**Our Ref: AL/21/18/HH**

**Town & Country Planning Act 1990 (as amended)  
Town & country Planning (Development Management Procedure) (England) Order 2015  
Application for Householder Planning Permission**

**Development**    Conservatory  
**Location**        27 Ivy Close Westergate

27 104 Close P0203RF
 Block Site Plan with Measurements
 to Boundaries

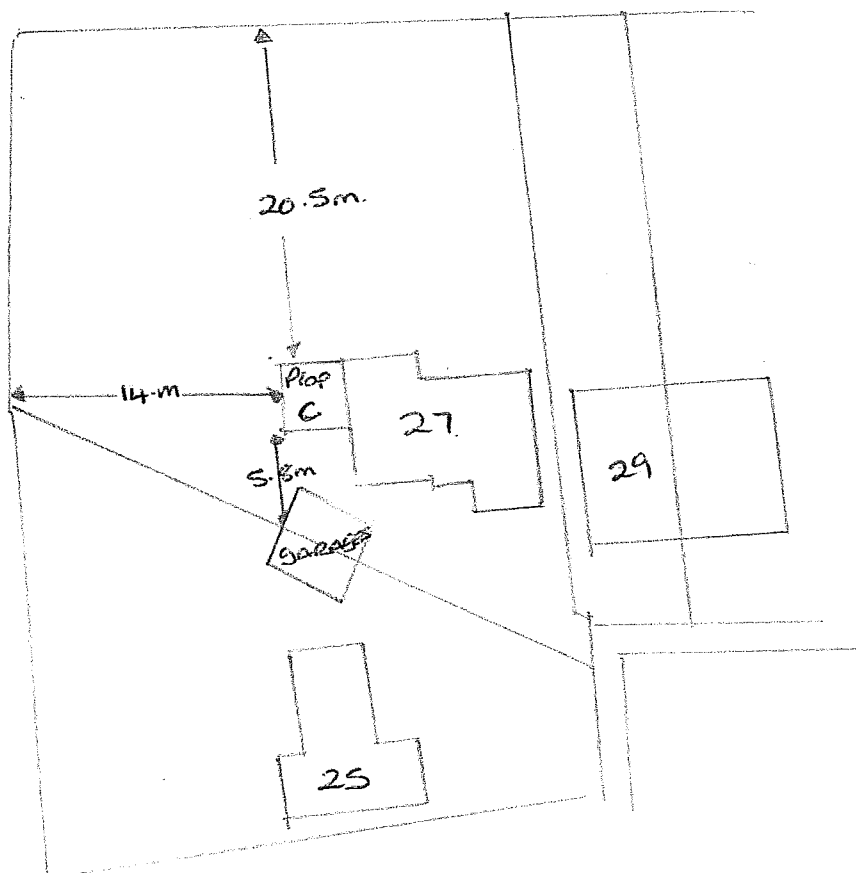
Block Plan

Please submit 1 electronic or 3 paper copies of an amended block/site plan at a scale of 1:500 or 1:200 showing the measurements from the proposal to the boundaries

EXISTING FLOOR PLAN

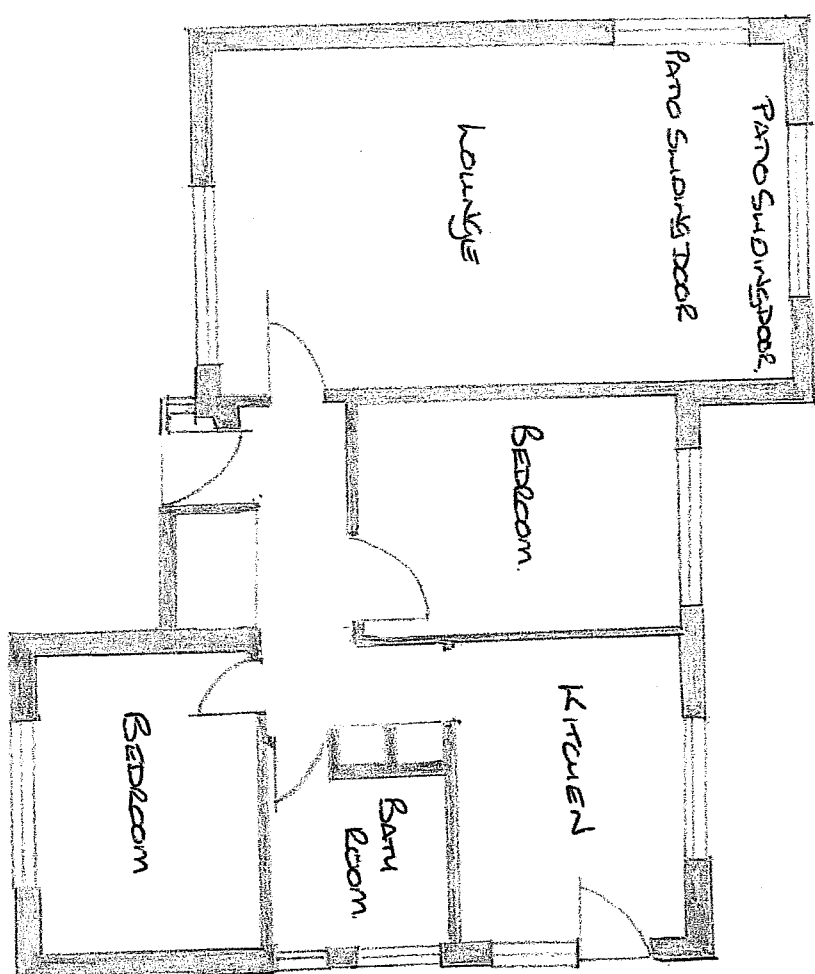
Floor Plans

Please submit 1 electronic or 3 paper copies of clearly labelled existing floor plans at a scale of 1:50 or 1:100

EXISTING ELEVATION

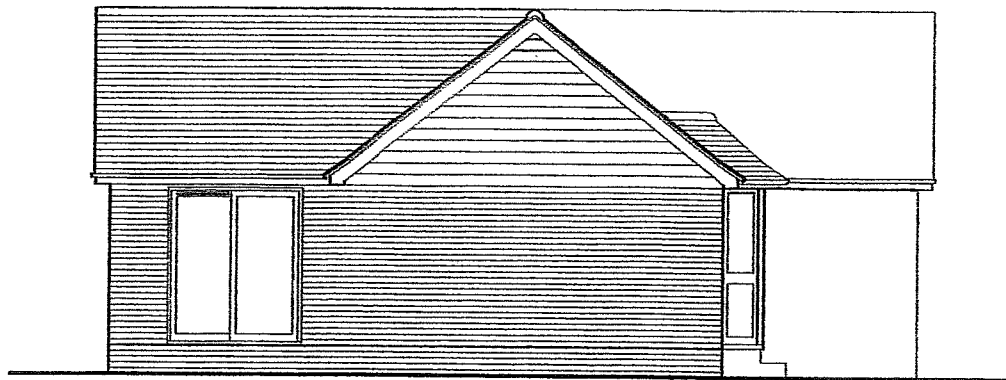
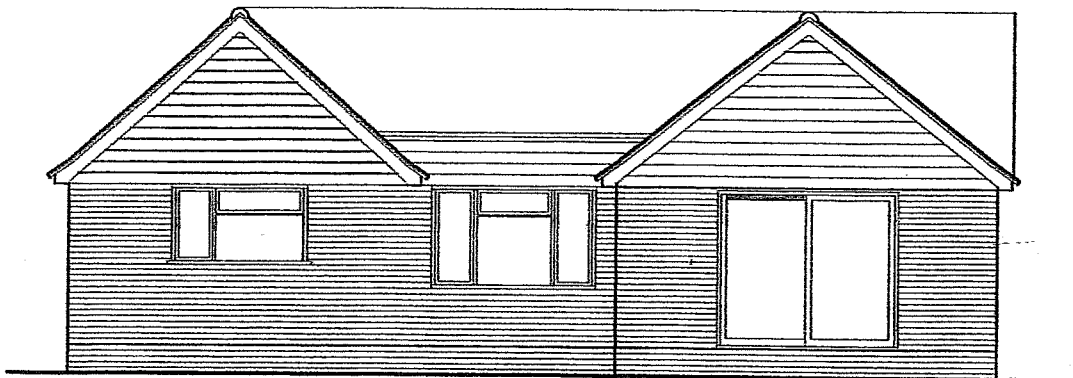
Elevations

Please submit 1 electronic or 3 paper copies of clearly labelled existing elevations at a scale of 1:50 or 1:100
